Our ref: DOC21/934112

**RE: Snowy 2.0, Main Works, Snowy Valleys, Monaro Regional, MOD 1 - Main Access Tunnel to Marica Services Connection (SSI -9687 Mod - 1)**

- *Snowy 2.0 Main Works - Modification 1, Main Access Tunnel to Marica Services Connection prepared by EMM Consulting Pty Ltd dated September 2021.*

Snowy 2.0
Modification to Snowy 2.0 Main Works
Figure 2.1

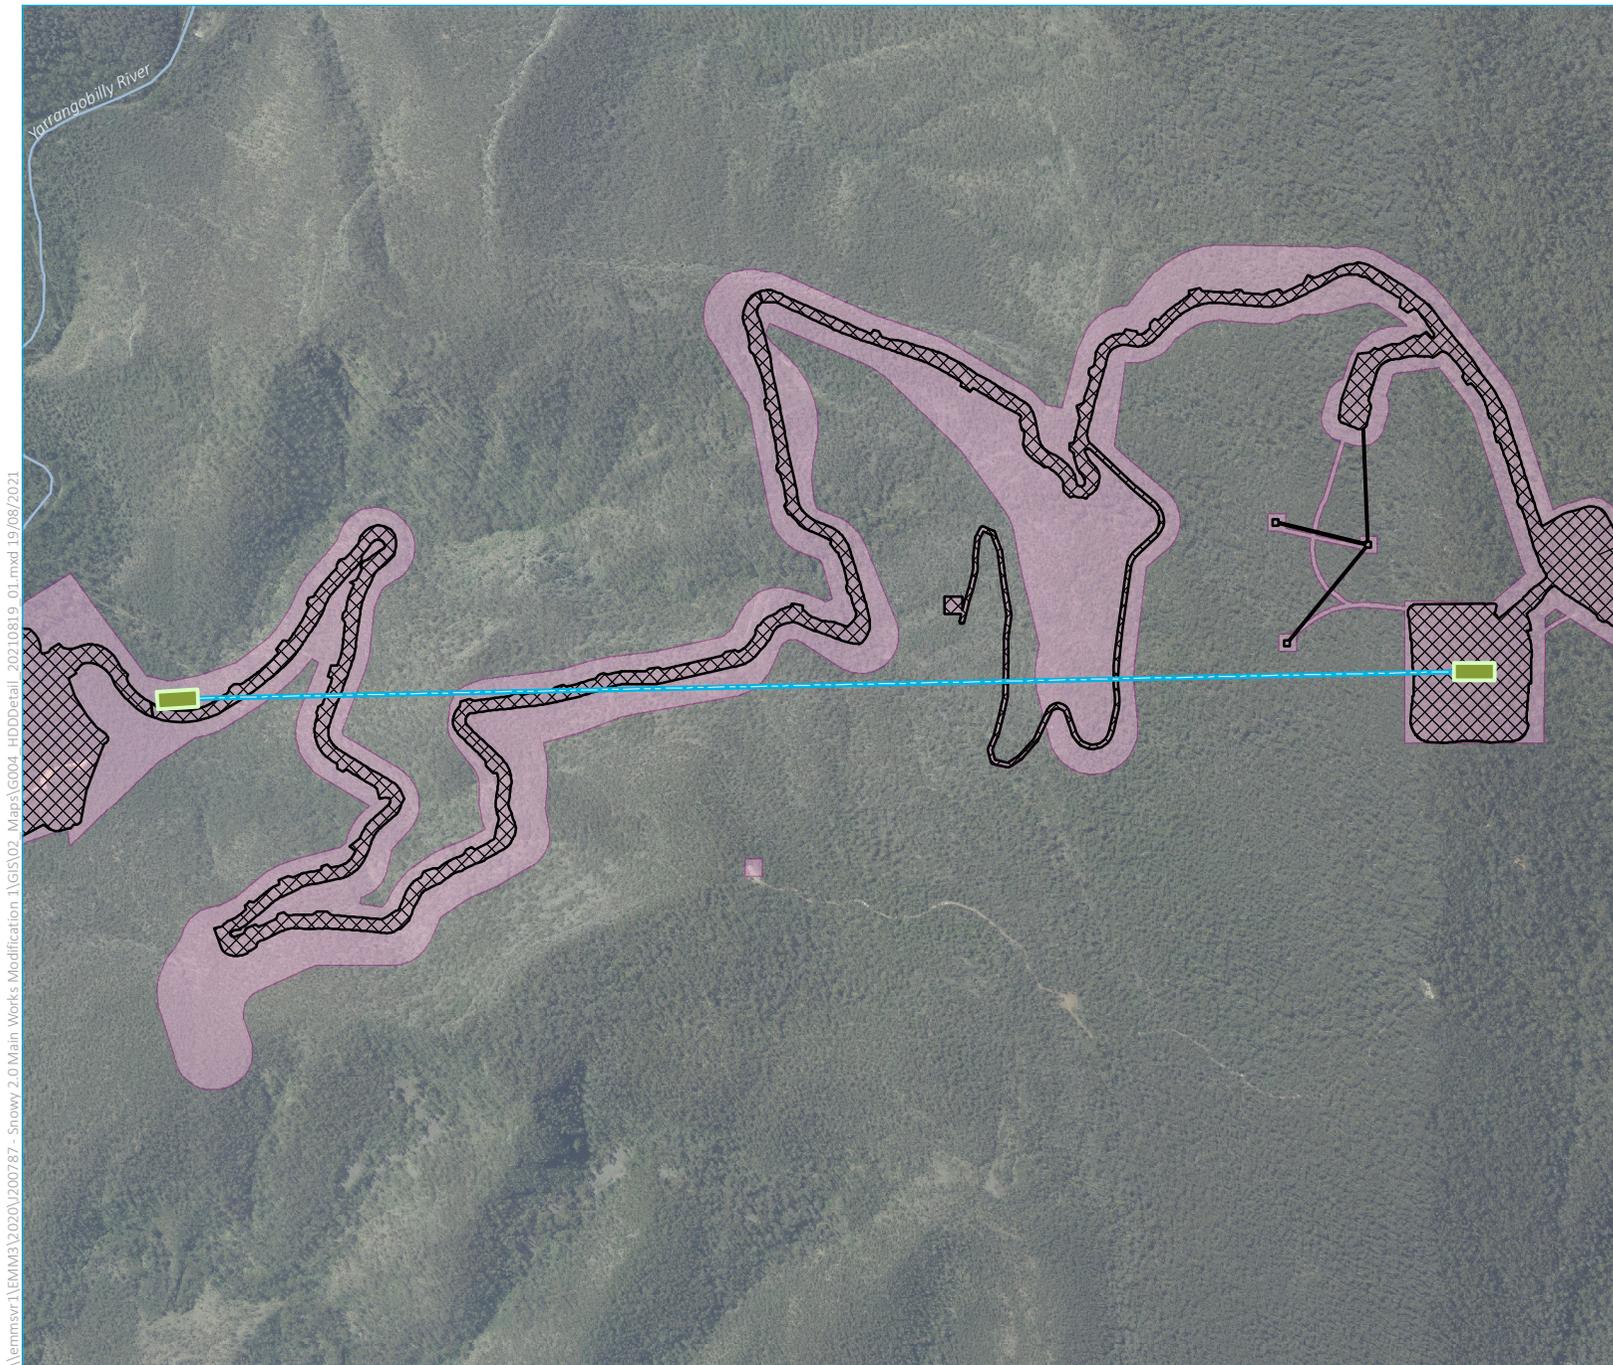
EMM 2021 concludes that there will be no additional impacts as a result of the modification further to those approved under the SSI (Table 4.1, p27). Figure 2.1 (EMM 2021) does not clearly show the location of proposed works relative to the heritage mapping included in the project's 2019 SOHI (NSW Archaeology Pty Ltd). It is therefore difficult to correlate locations of work to confirm that the areas of impact do not contain heritage items or historical archaeological relics in locations where the horizontal directional drilling, or the associated boreholes to install the requisite pipes are proposed for installation.

However, Heritage NSW has considered that Figure 2.1 in the EMM 2021 report shows areas of previously approved impact align with what is presumed to be the main set up locations for the HDD program. Heritage NSW also notes that a significant quantum of investigative works that included salvage was undertaken as part of the Early works project for the Snowy project including at Lobs Hole. On this basis, HNSW concurs it is unlikely that additional impacts to archaeological relics are anticipated from the modification areas.

If future modifications are proposed for the project, Heritage NSW recommends clearer mapping to justify conclusions would be beneficial to demonstrate statements in the supporting documents.
